**Re: EXHIBITION OF STATE SIGNIFICANT DEVELOPMENT APPLICATION SSD-8586218**

<b>PROPOSAL:</b>	<b>TEMPERATURE CONTROLLED WAREHOUSE FACILITY</b>
<b>ADDRESS:</b>	<b>LOT 4, BRINGELLY ROAD BUSINESS HUB, LEPPINGTON (LOT 11 DP 29104)</b>

Level 57, MLC Centre 19-29 Martin Place,
Sydney, NSW 2000
www.habit8.com.au
P: (02) 9360 7771

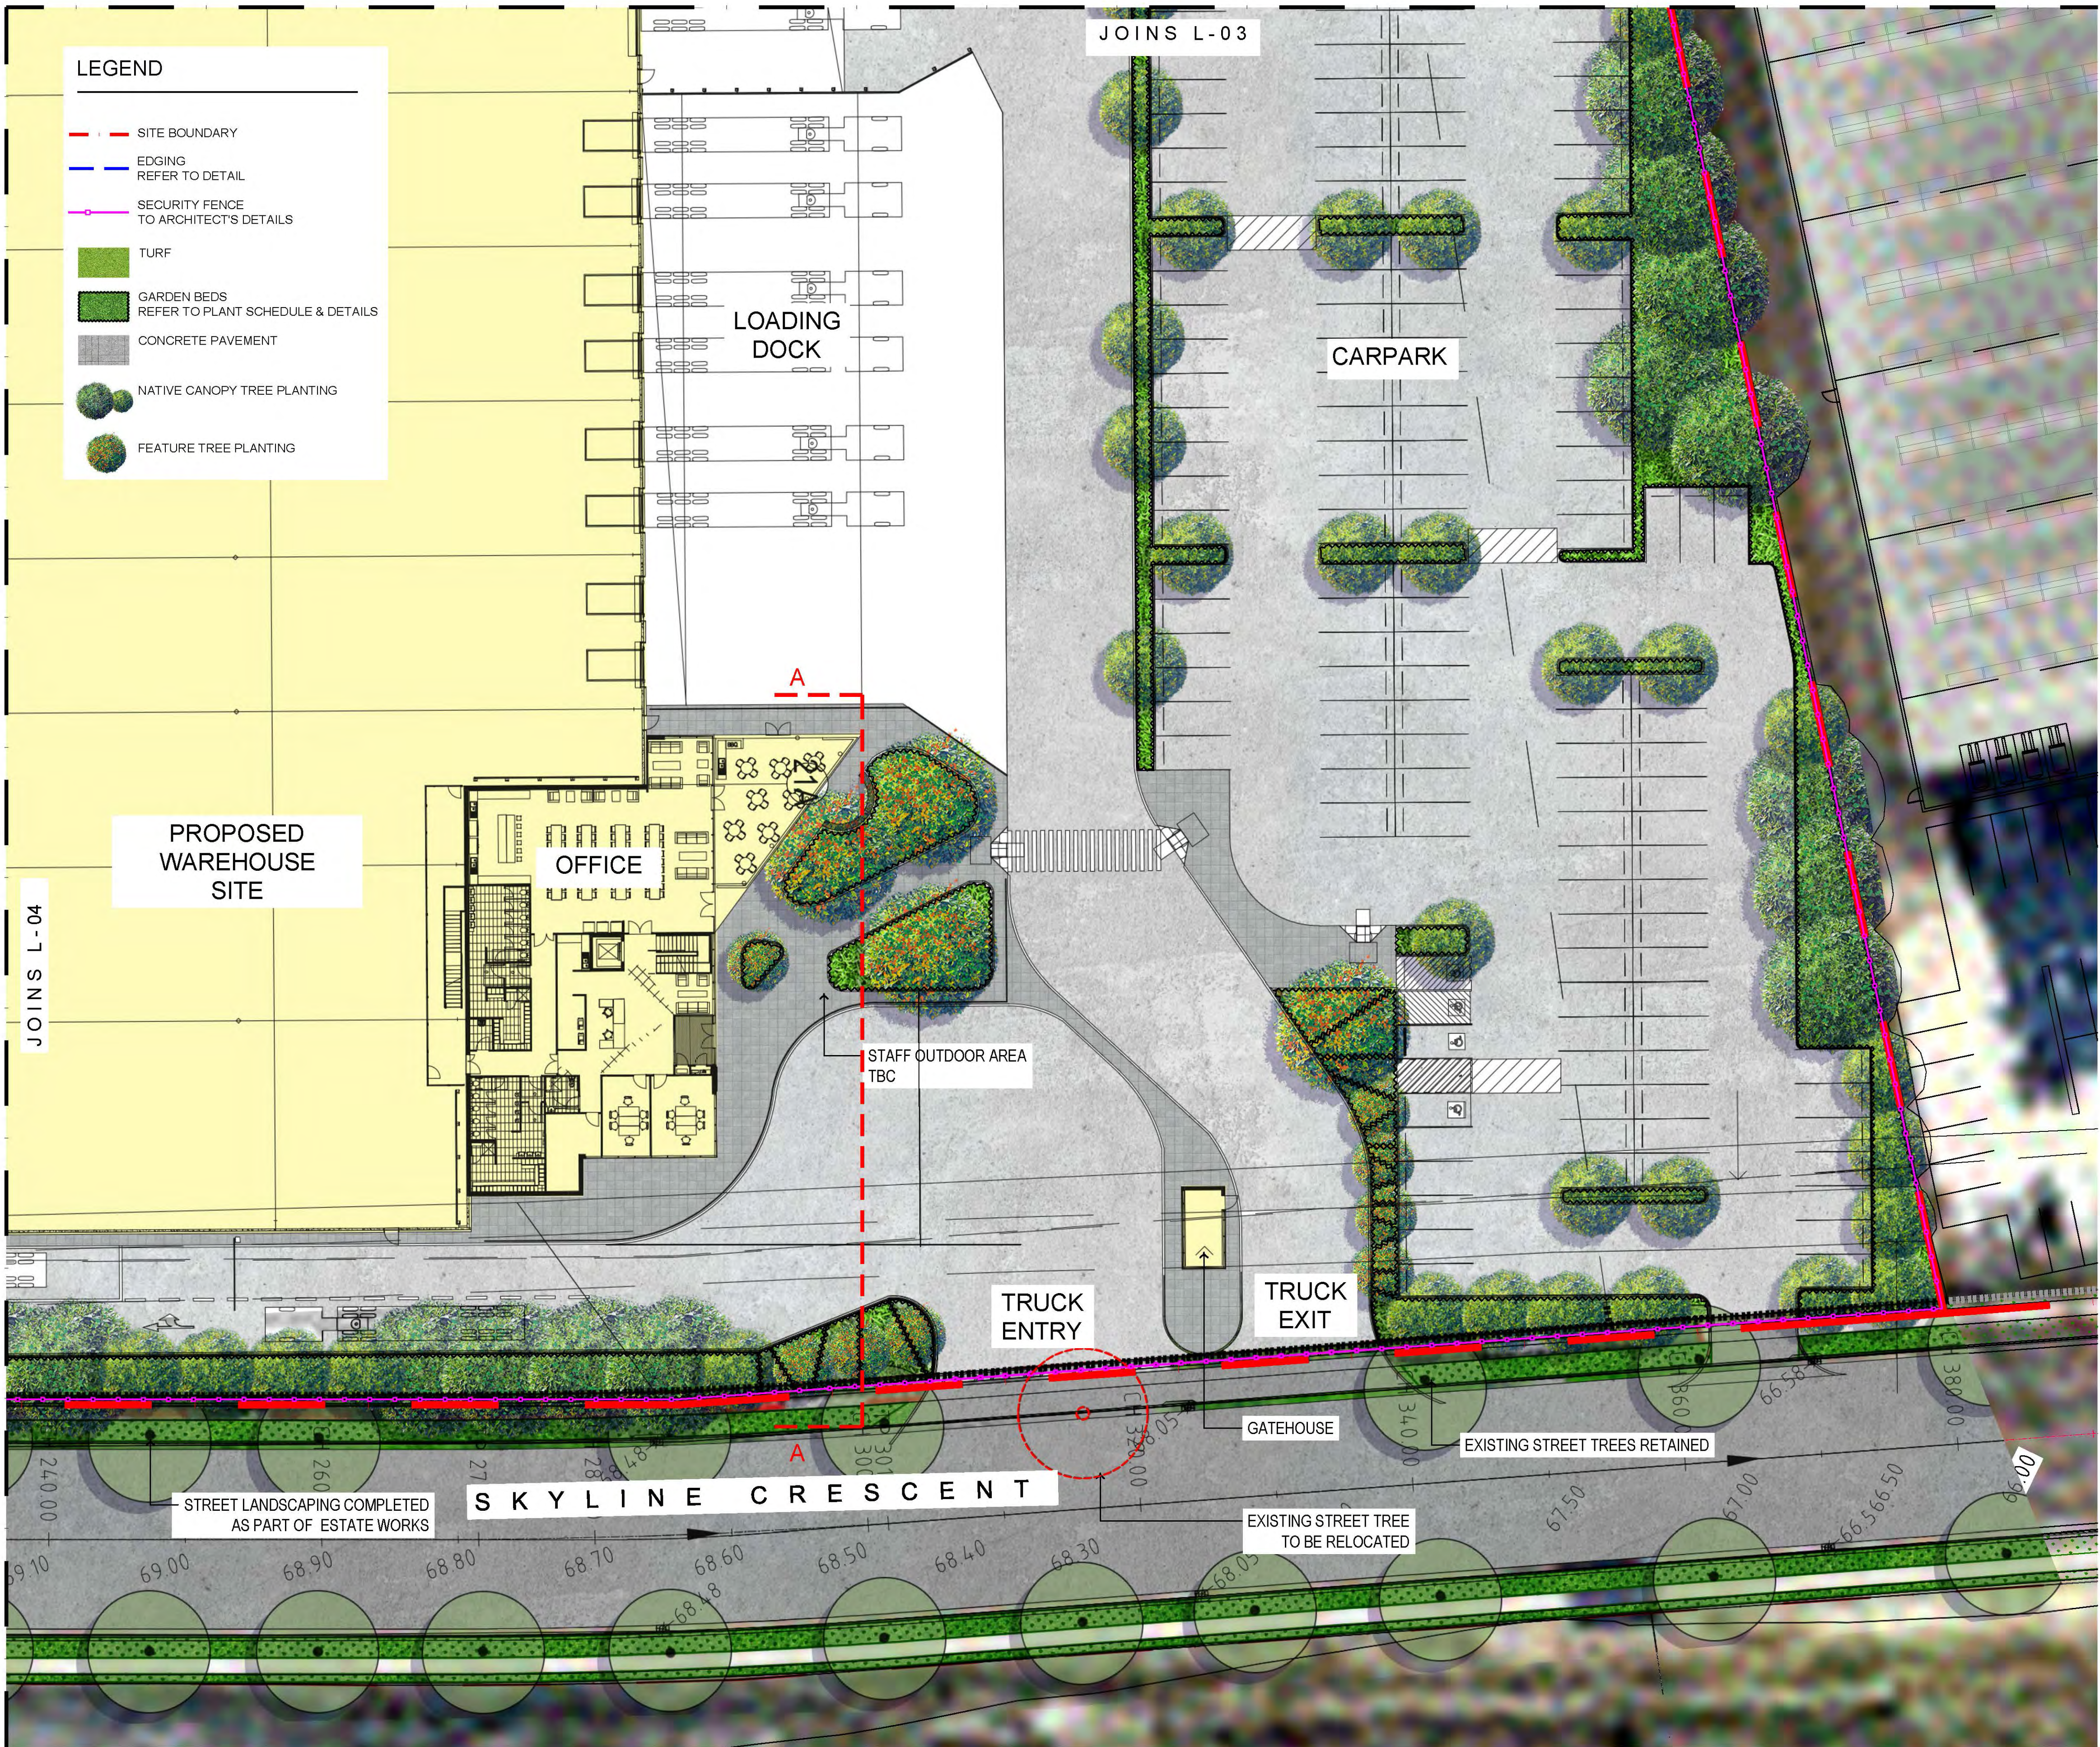
2. Council commends the incorporation of landscaping at the site. Notwithstanding this, it is important to maximise the amount of landscaping to ensure an optimal sustainability outcome. Having regard to the submitted traffic report, it is noted that there are hardstand areas adjacent to the perimeter planting that do not appear to be required for vehicle maneuvering and/or parking. In this case, there appears to be scope for an increase in landscaped areas around the perimeter of the site.
3. Council has reviewed the submitted landscape plan prepared by Habit8. It is noted that this plan indicates planting on the site yet does not denote the plant species. Furthermore, it is noted that the plant schedule does not provide details of the height and the canopy spread of each plant species. The landscape plan should be amended to rectify these matters.

Notwithstanding this, having regard to the submitted visual assessment, it is noted that the trees used on the site, especially those in the car park area and along the Stuart Street frontage do not appear to provide large canopy cover. It is recommended that the applicant provide for species with a larger canopy to provide more shaded areas and adequate screening.
